NSIP Reference Code: TR010065

Natural England's comments in respect of the A46 Newark Bypass

Natural England's Relevant Representations

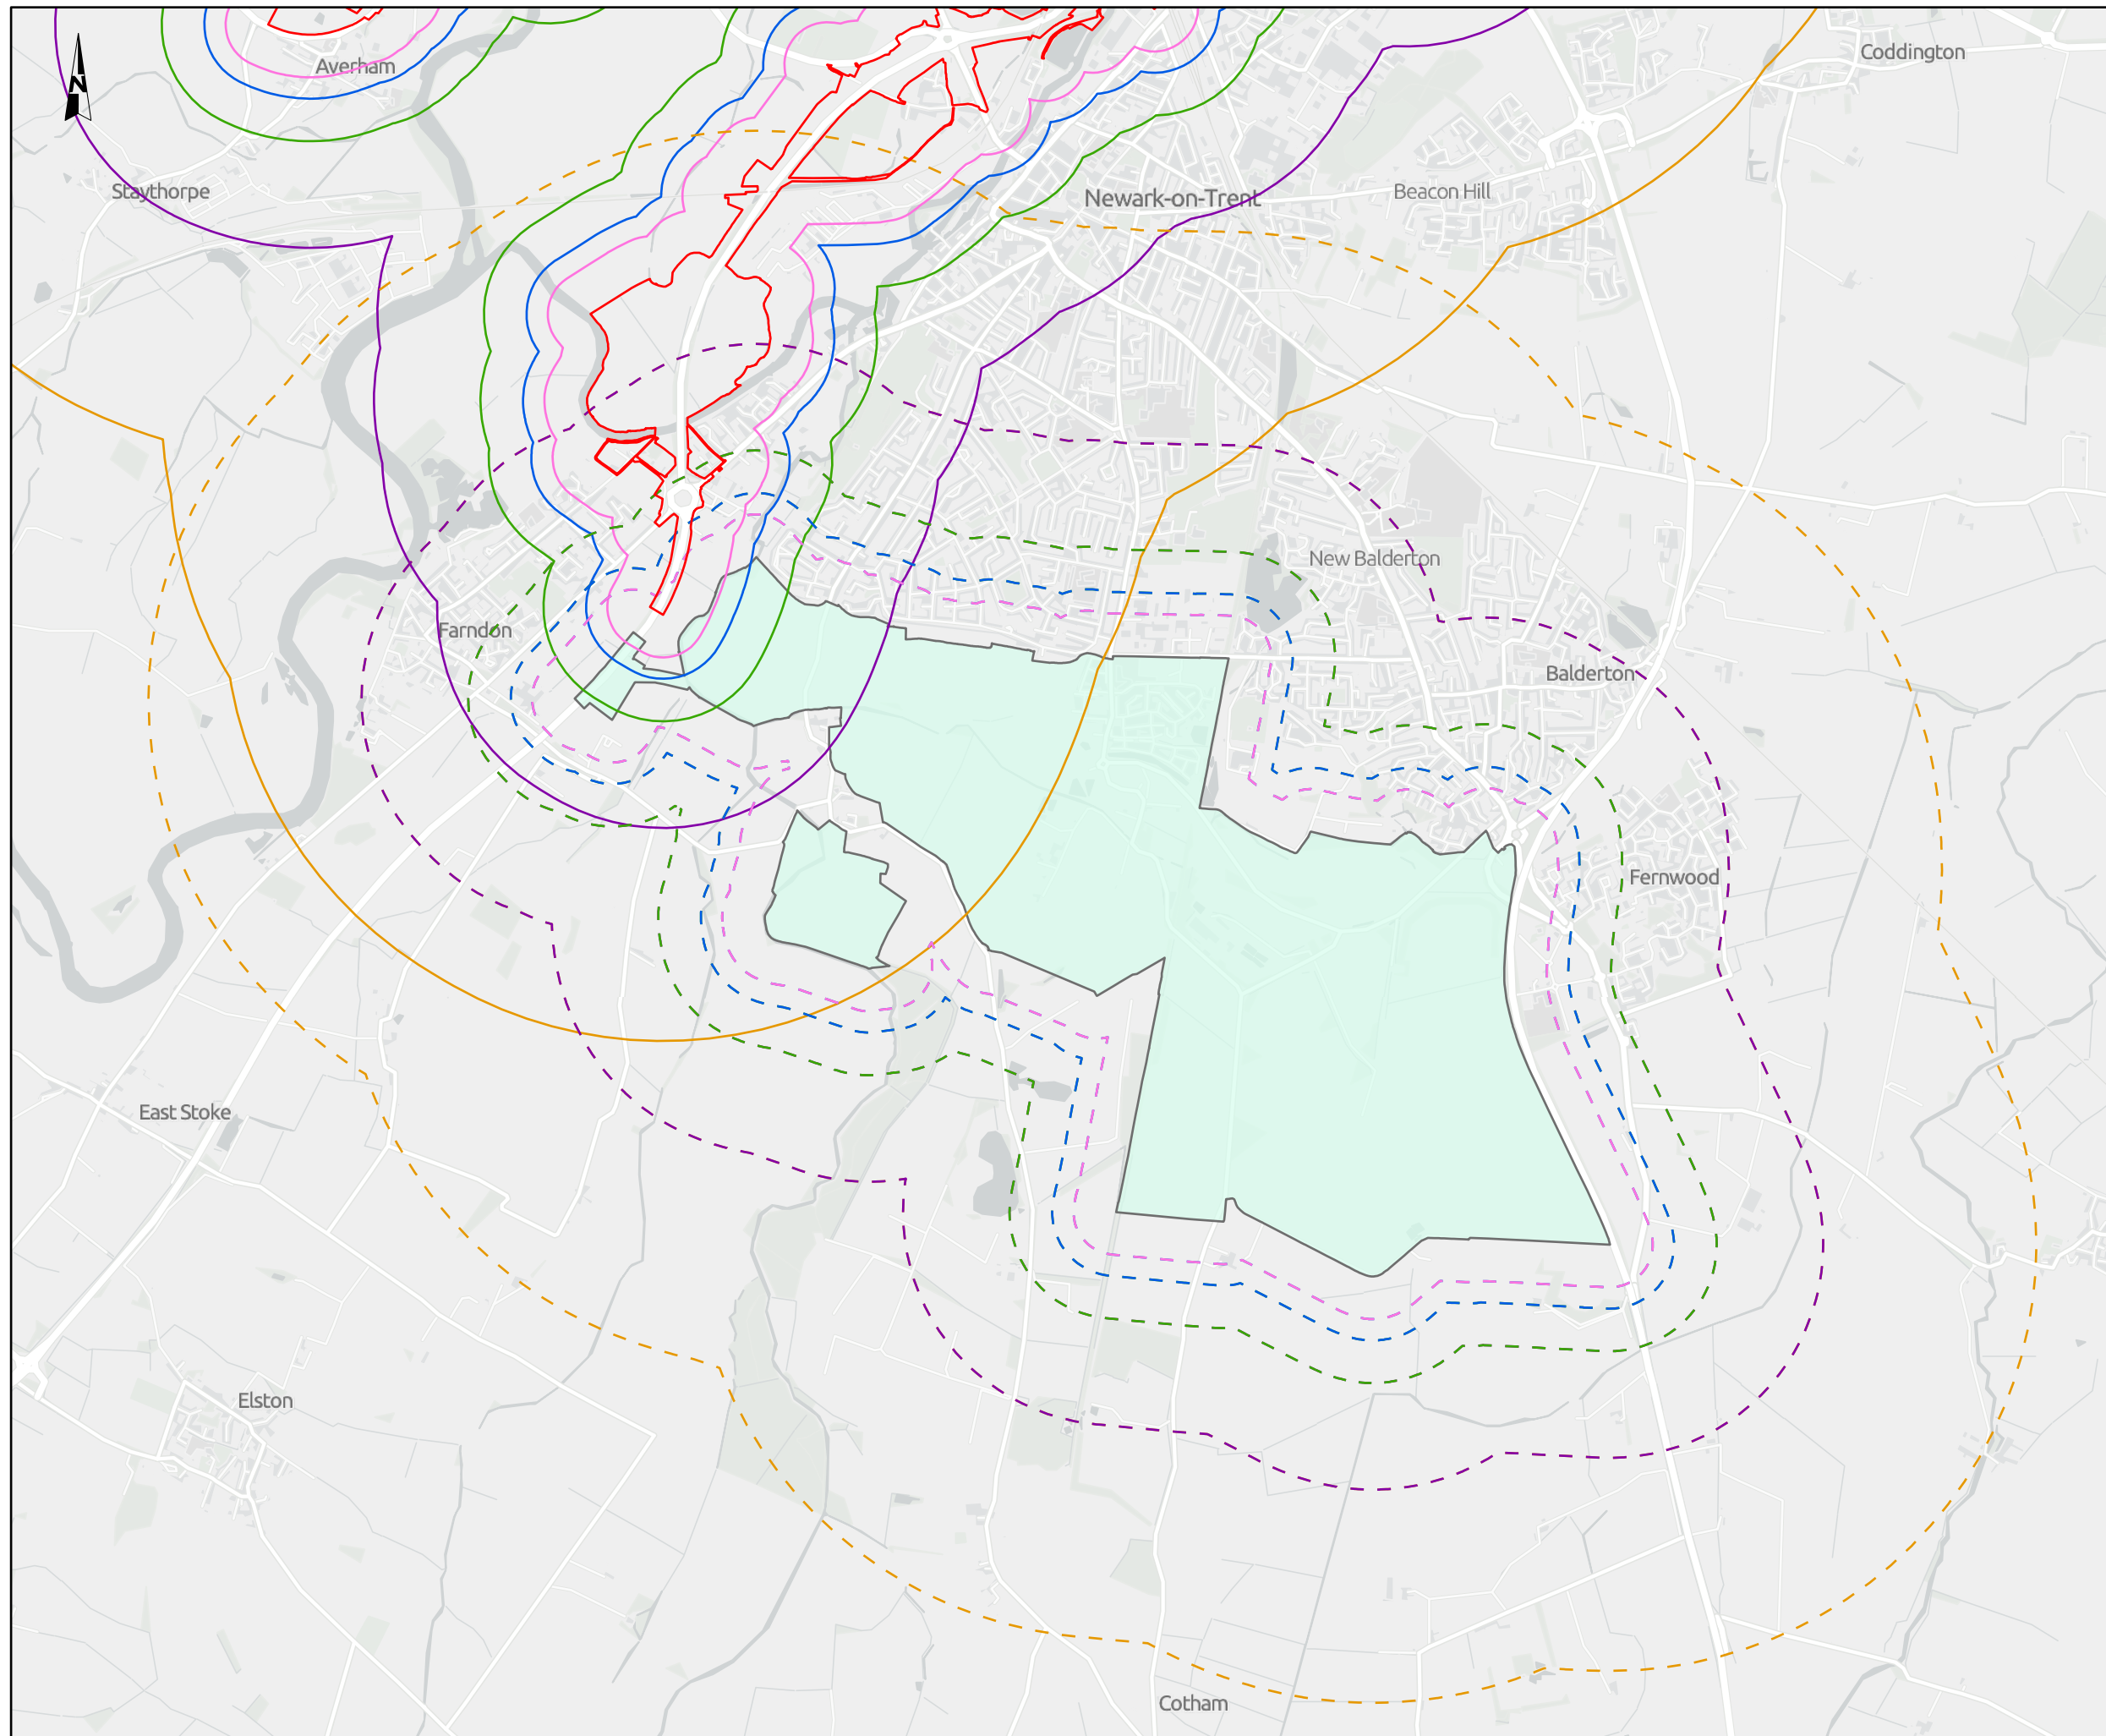
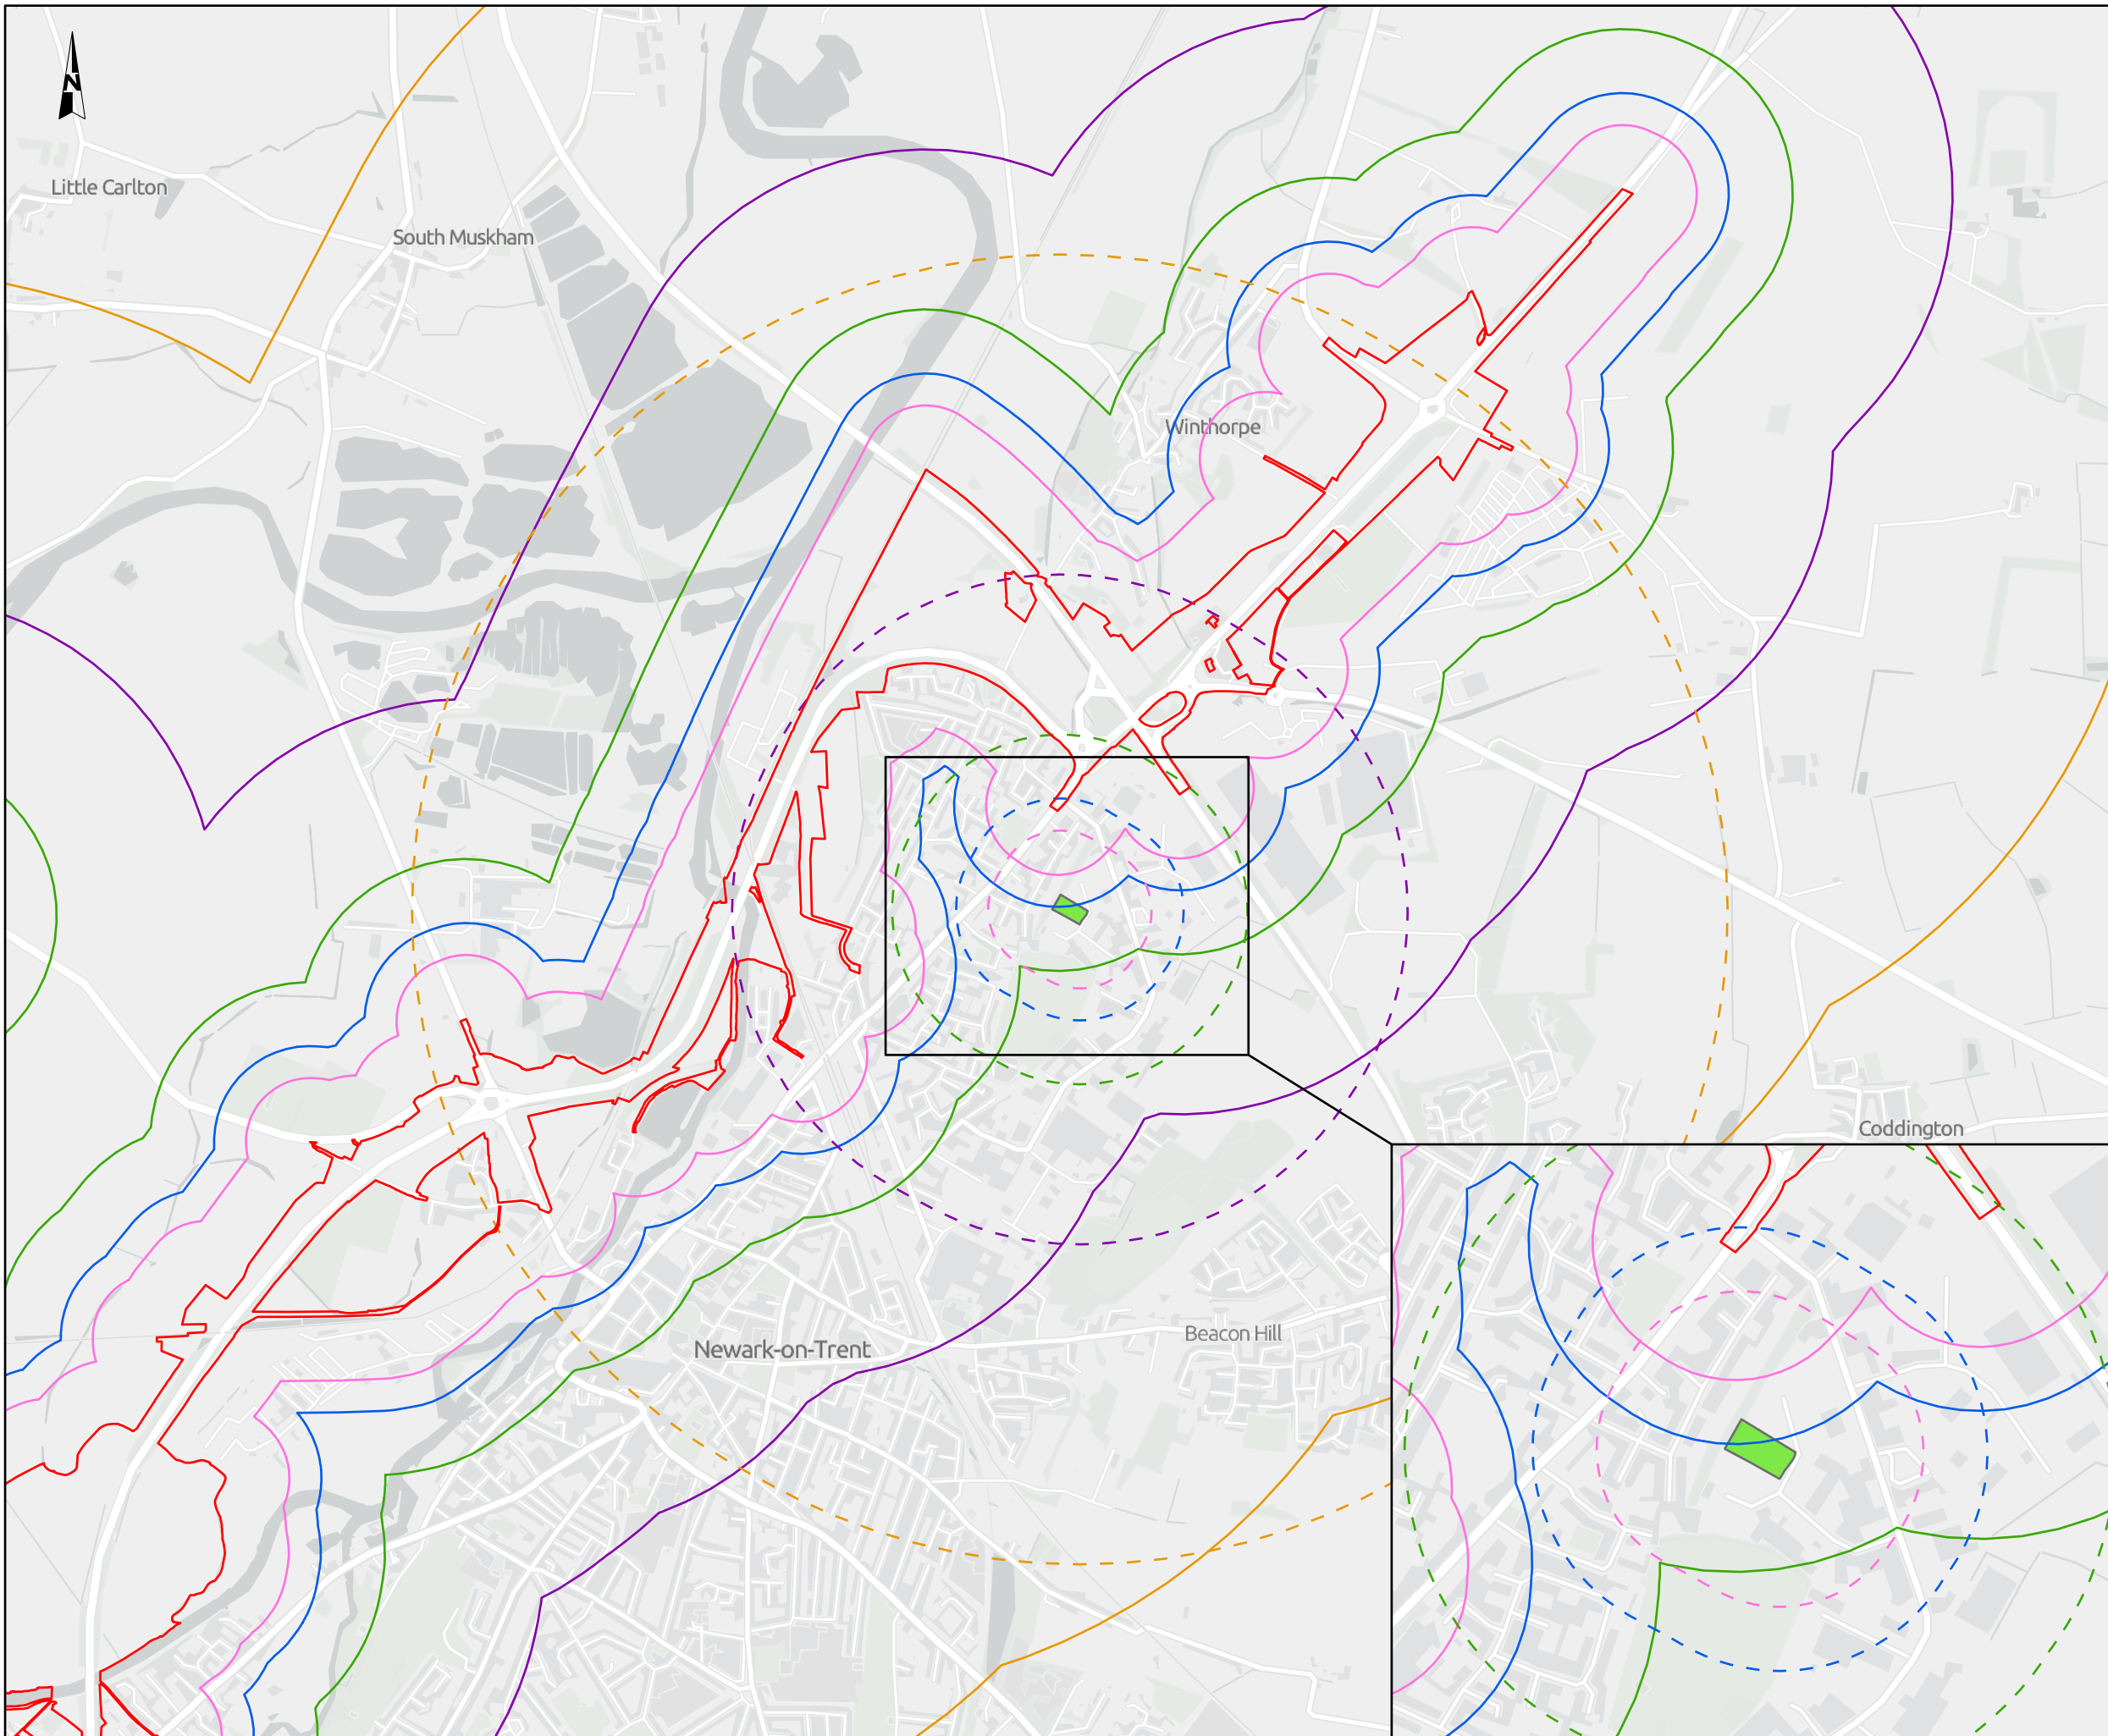
NE5	International designated sites <ul style="list-style-type: none"> • Humber Estuary SAC • Humber Estuary Ramsar 	HRA screening in-combination: Assessment of scheme location criteria (Construction and operational phases)	<p>Within the HRA in-combination assessment table (Stage 1: Screening; p40-48), projects are listed by distance from the SAC/ Ramsar. It is suggested that distance from the project is also an important factor for consideration. This is due to the River Trent's functional linkage to the designated sites, therefore in-combination effects of projects upstream of the Humber Estuary have the potential to impact the international sites.</p> <p>It is recommended that a further review is undertaken to ensure no further projects located close to the development require assessment.</p>	Further information required.	Amber
